RFI

RFI #: 78
 Date: 3/16/2012
 Job: EB-02 Keller Springs Lofts
 Phone: 877-777-5115

Subject: Raising piers on north wall

SHEET NUMBER
S2.14P

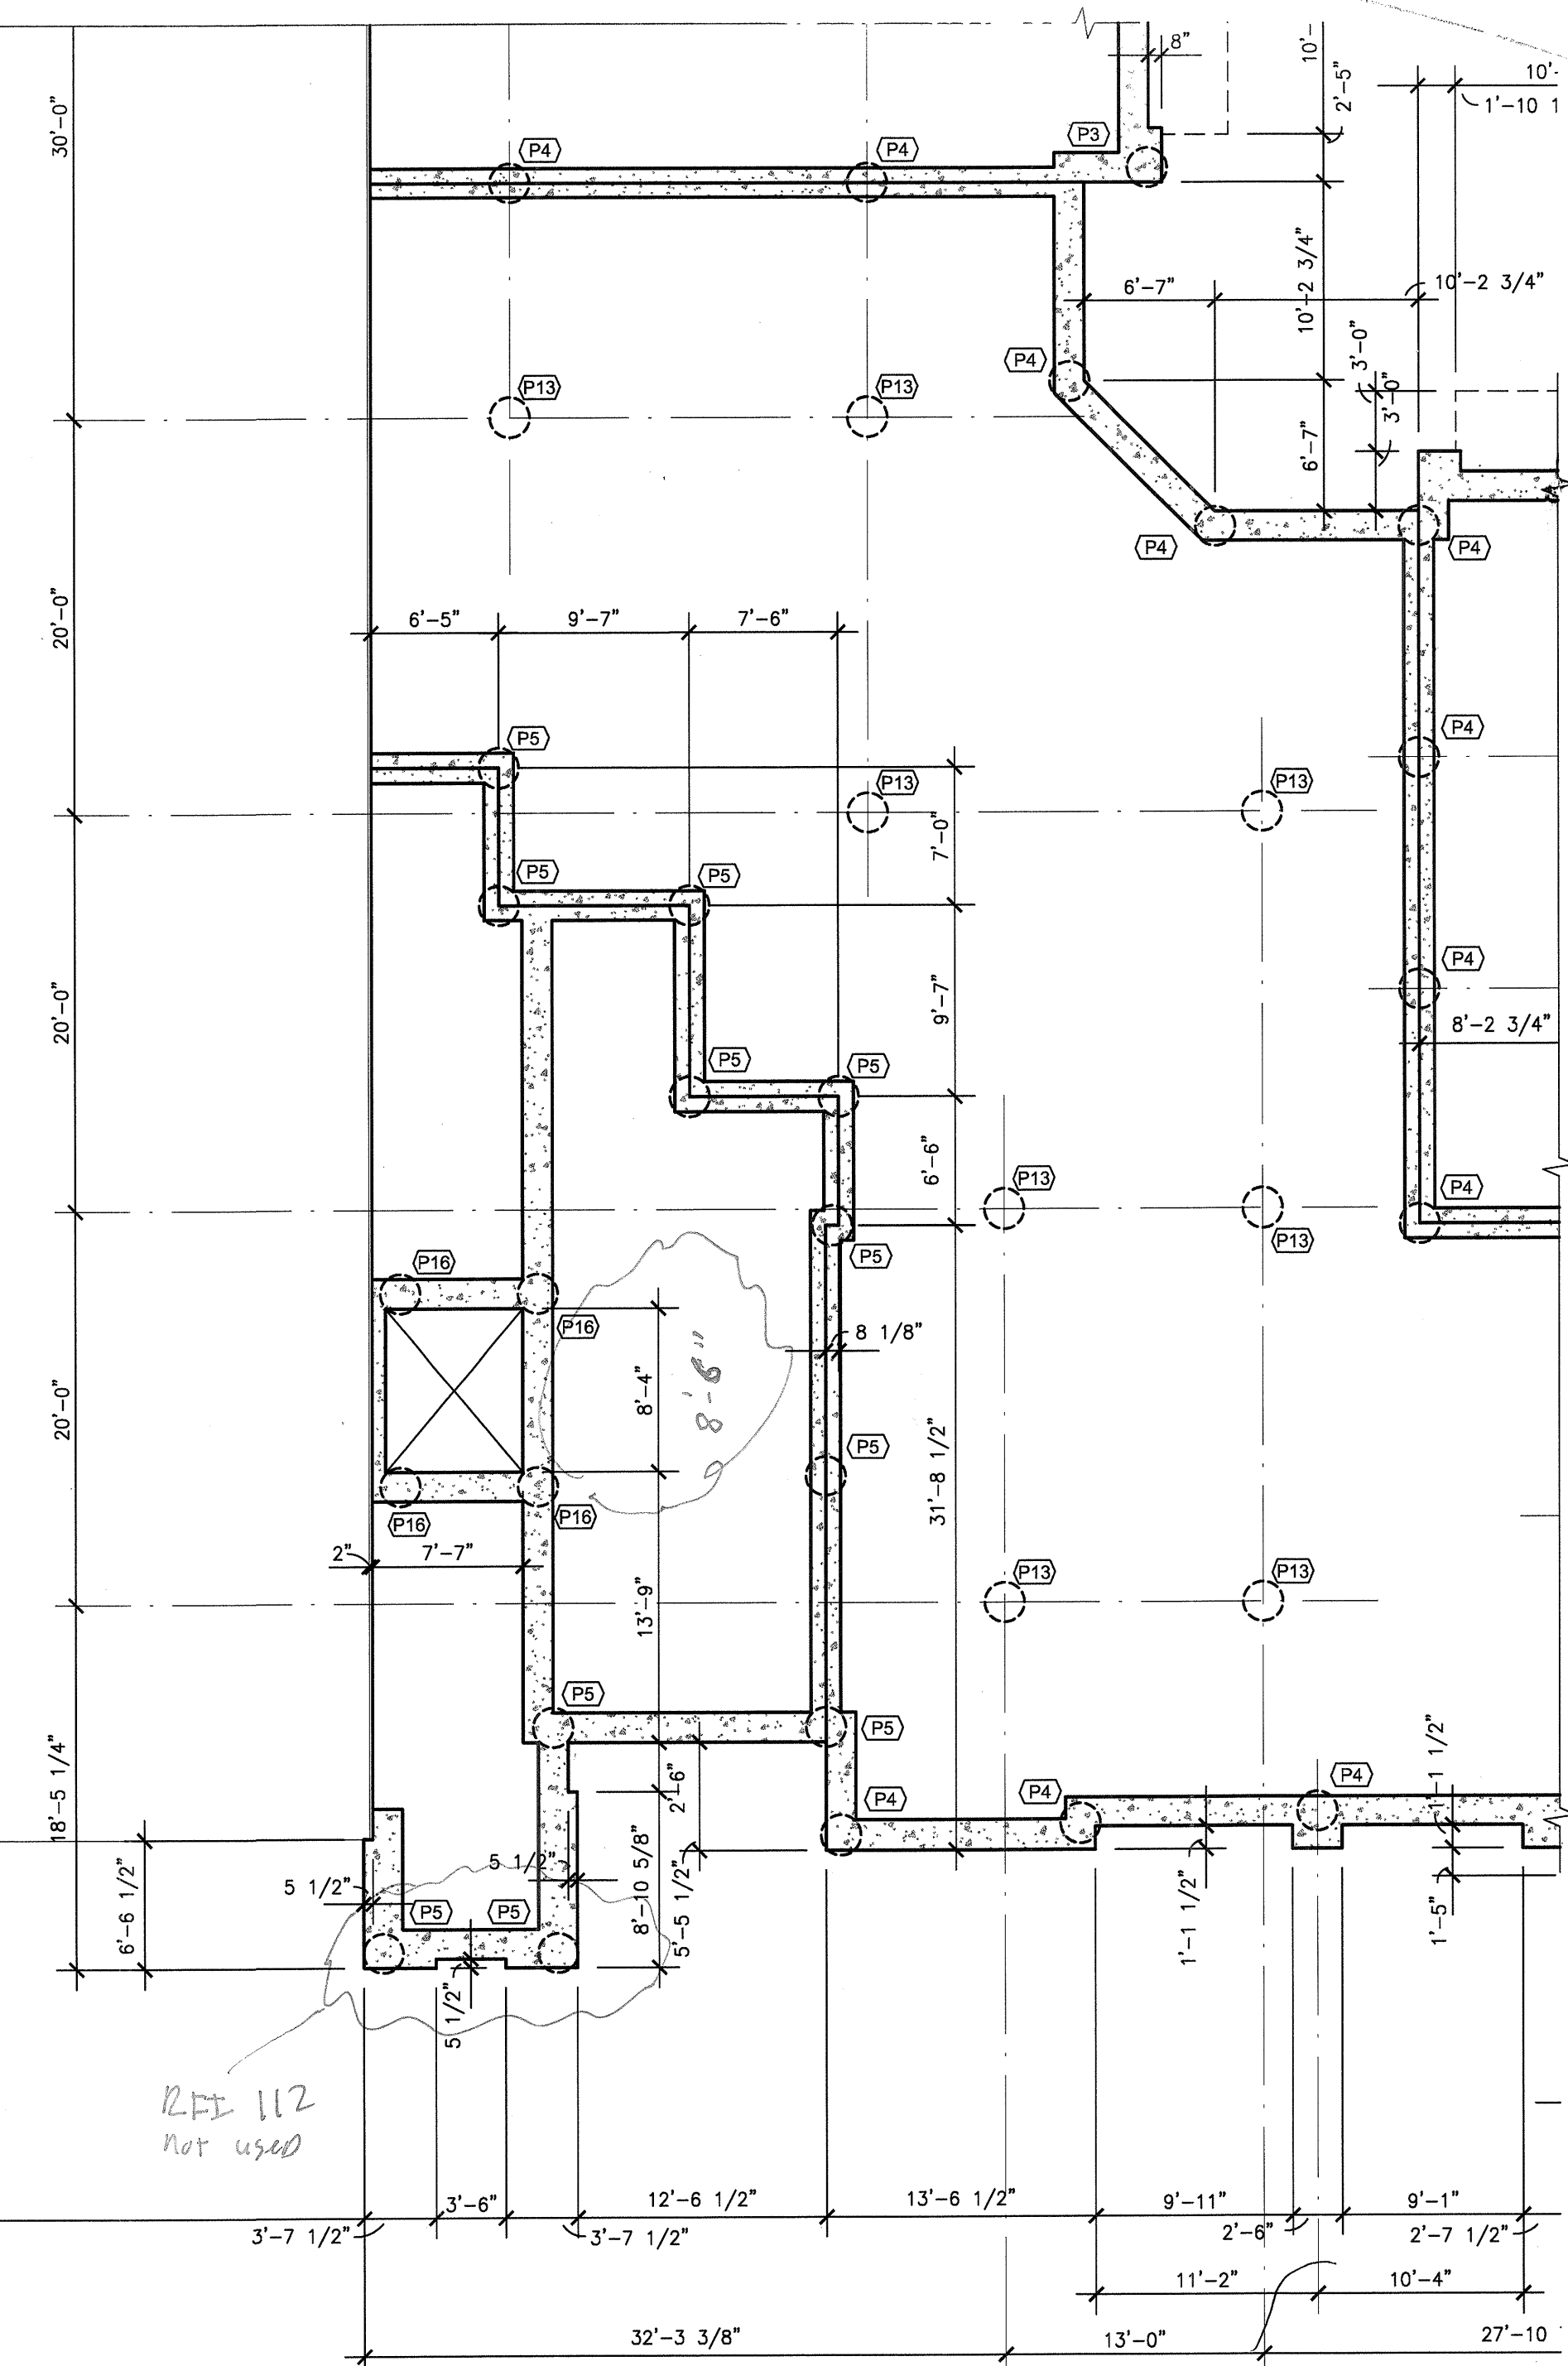
Request:
 As per our conversation during our meeting at your office, we would like to propose a change in the top of pier elevations for the P9, P9 & P7 piers. After reviewing the finished exterior grades on the landscape drawings 1C & 2C, we feel the top of pier elevation could be raised as follows:
 P9 - 639' - 9 1/4"
 P8 - 637' - 9 1/4"
 P7 - 638' - 0"
 By raising these it will also benefit the integrity of the perimeter storm drain line. We would also like a detail for using dowels & sonotube on the previously poured P9 piers.

Response:
 PPO takes no exception to raising the top of pier elevation as long as it does not conflict with external grades. Please verify with Architect/Civil Engineer that proposed top of pier elevations are acceptable.

Pier extensions should be formed with a sonotube form of the same diameter as the pier shaft and reinforced with 6-#7 verticals (drilled and grouted into the existing pier with a minimum of 13 1/8" of embedment in accordance with the manufacturer's recommendations) and #3 ties at 10" on center as noted in detail 1/S3.01.
